Our Ref: RVBC-MH-APP-002 (2)

Date: 26/January/2022

**PLANNING APPLICATION Ref: 3/2021/0661 - Haweswater Aqueduct Resilience Programme  
Proposed Marl Hill Section (Ribble Valley Borough Council)**

**APPLICATION UPDATES**

Tree Survey Information

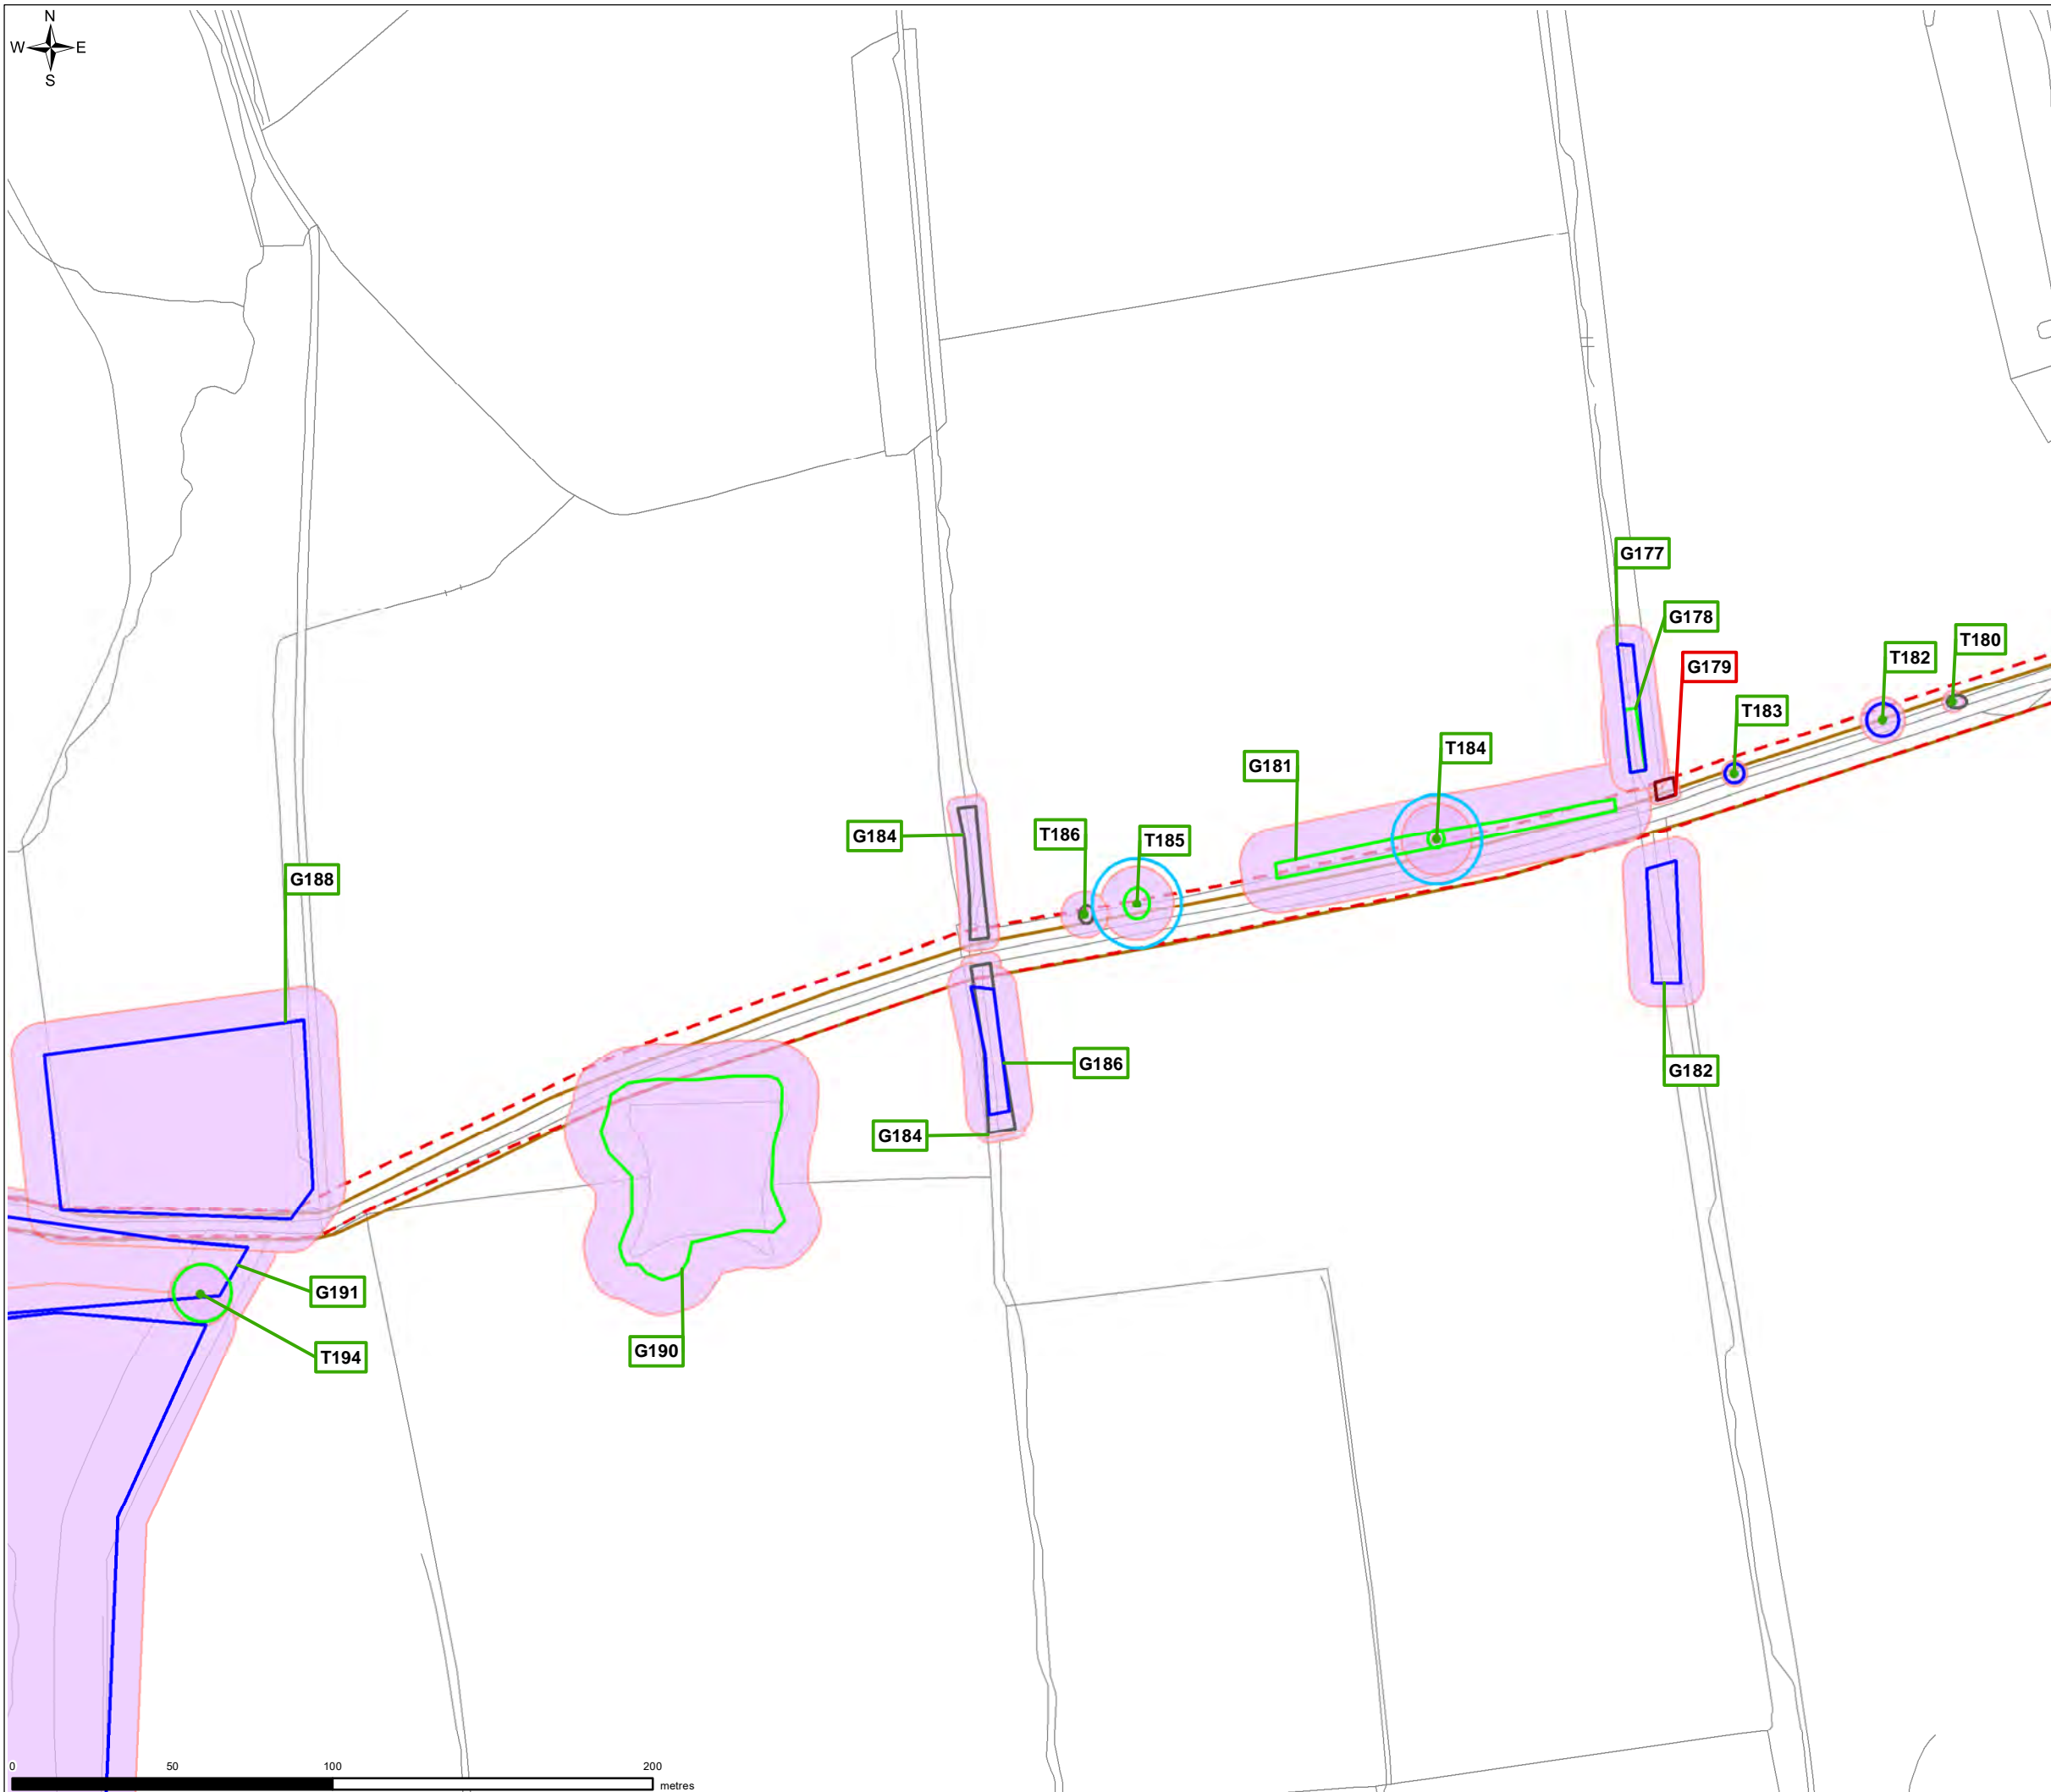
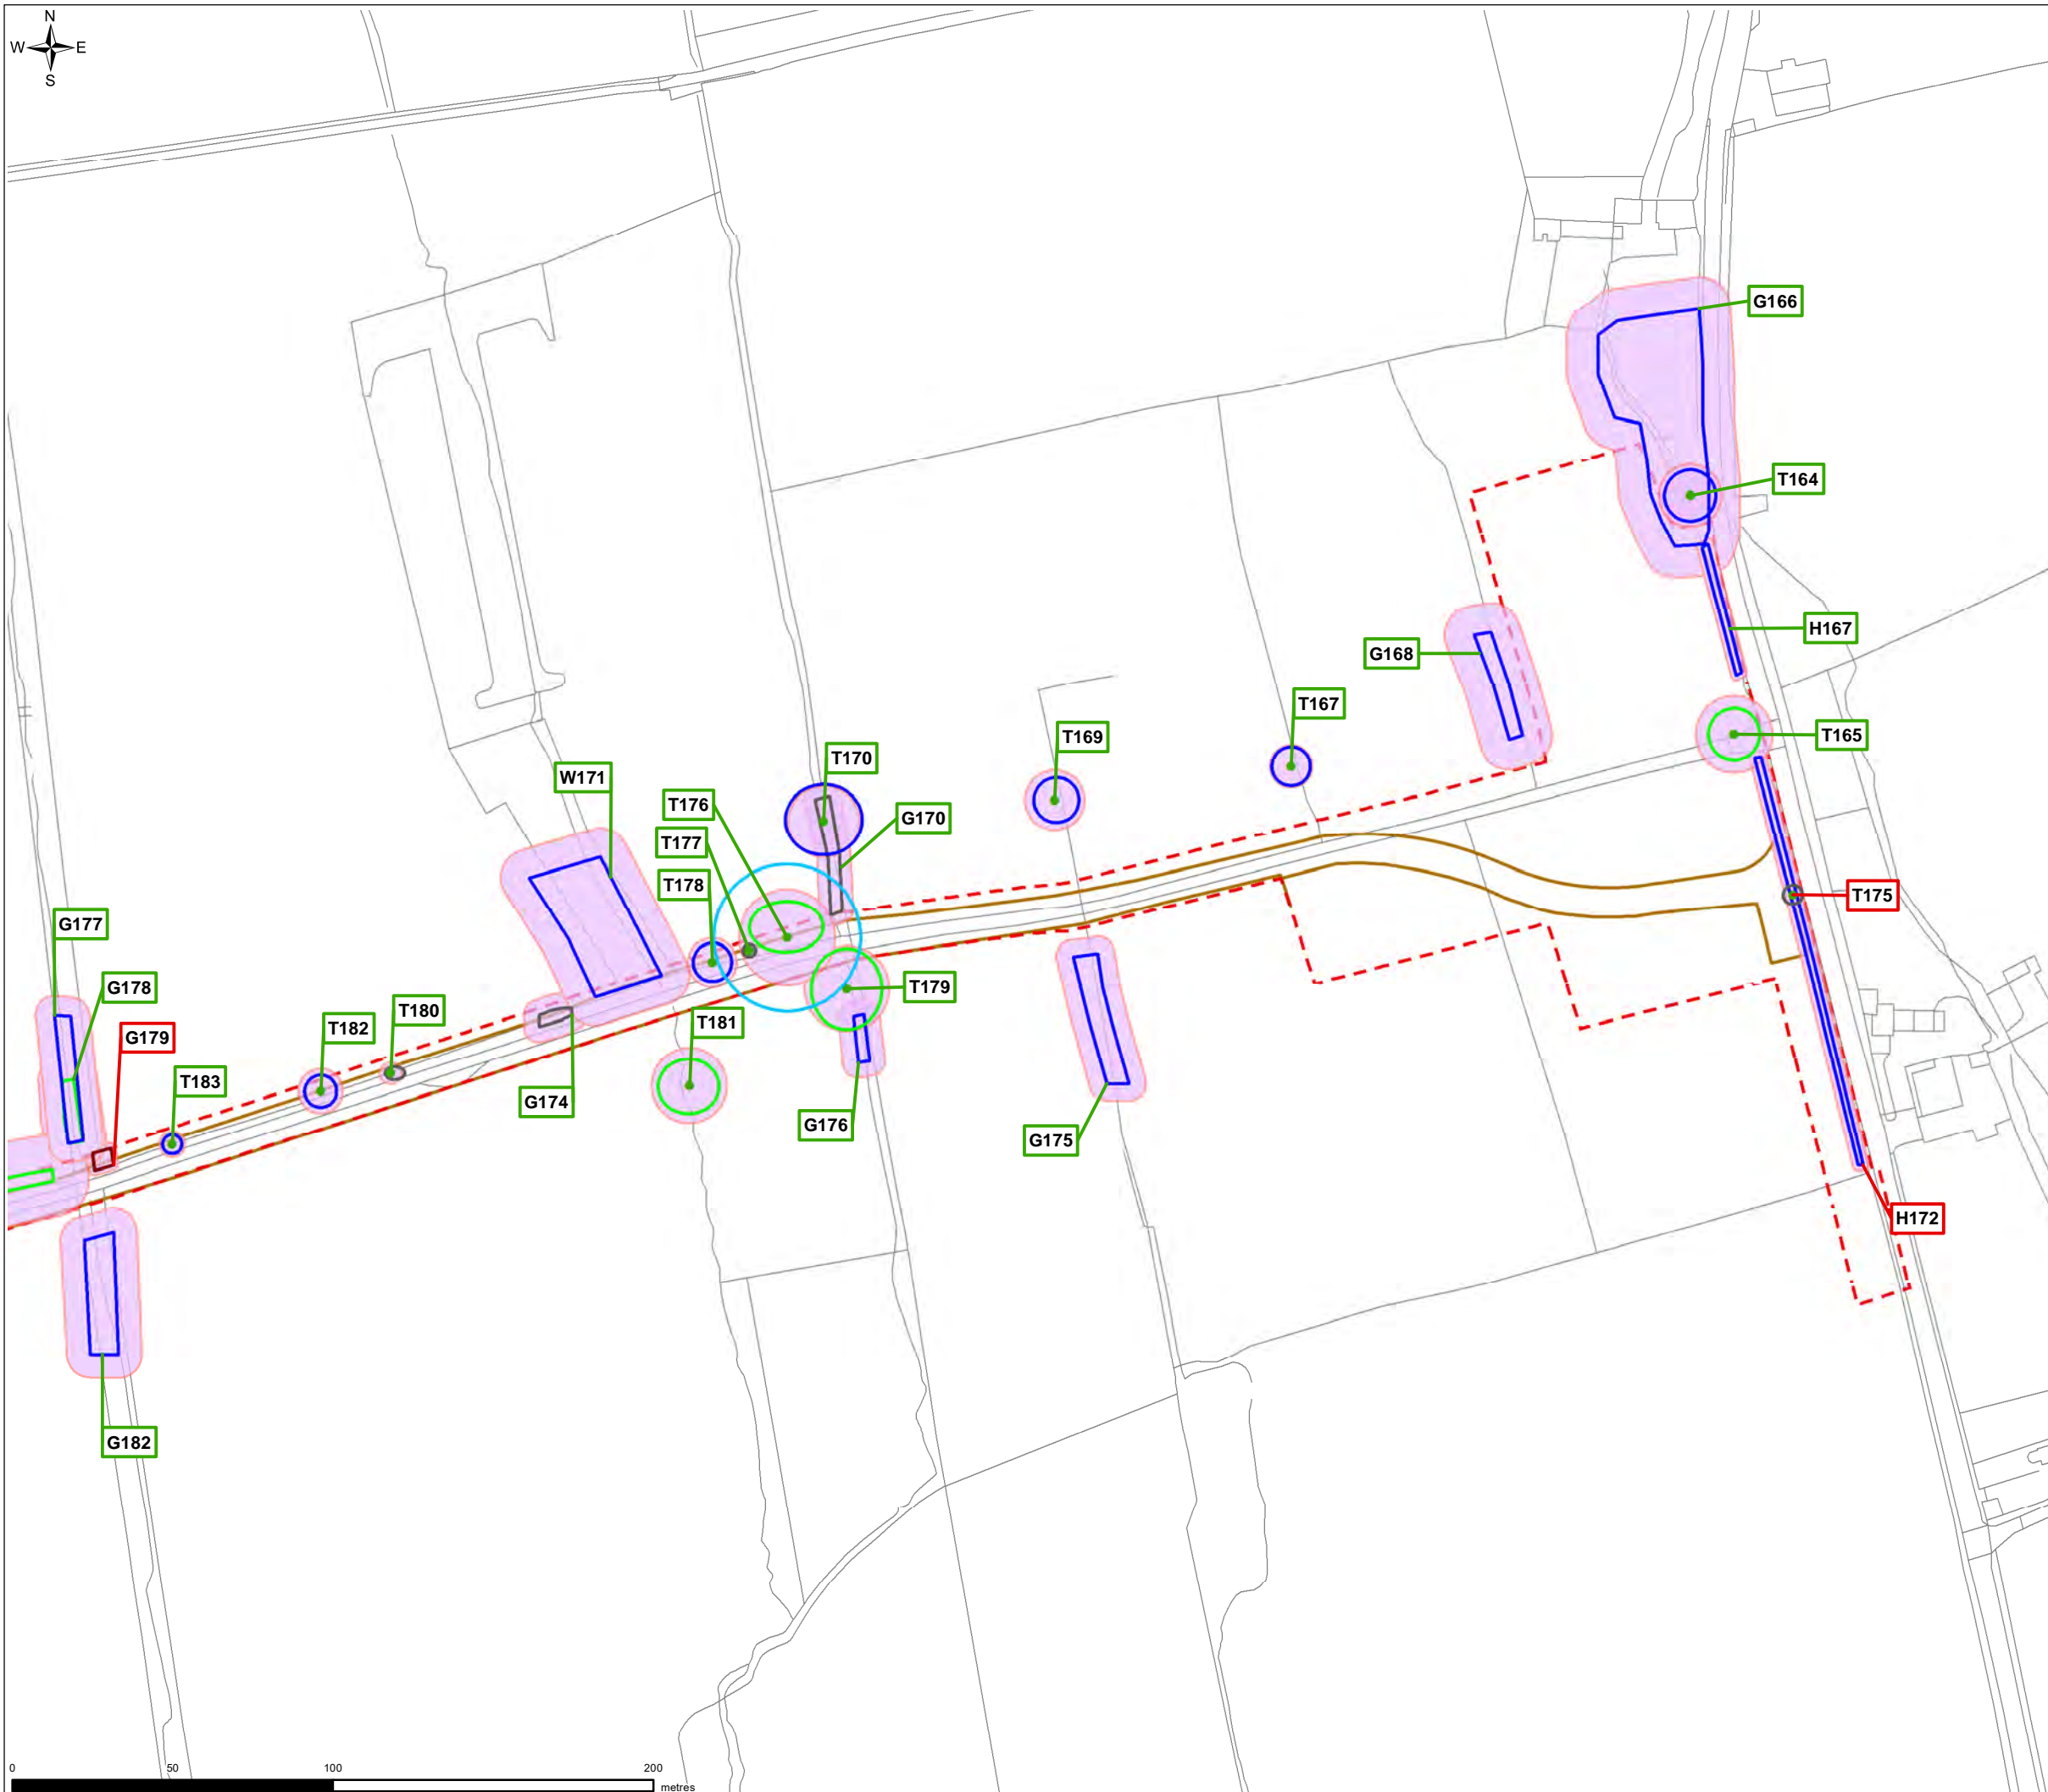
Further design refinement has led to the avoidance of some previously proposed affected trees within the construction compounds and these are reflected on the updated Series 3 - Site Layout Plans.
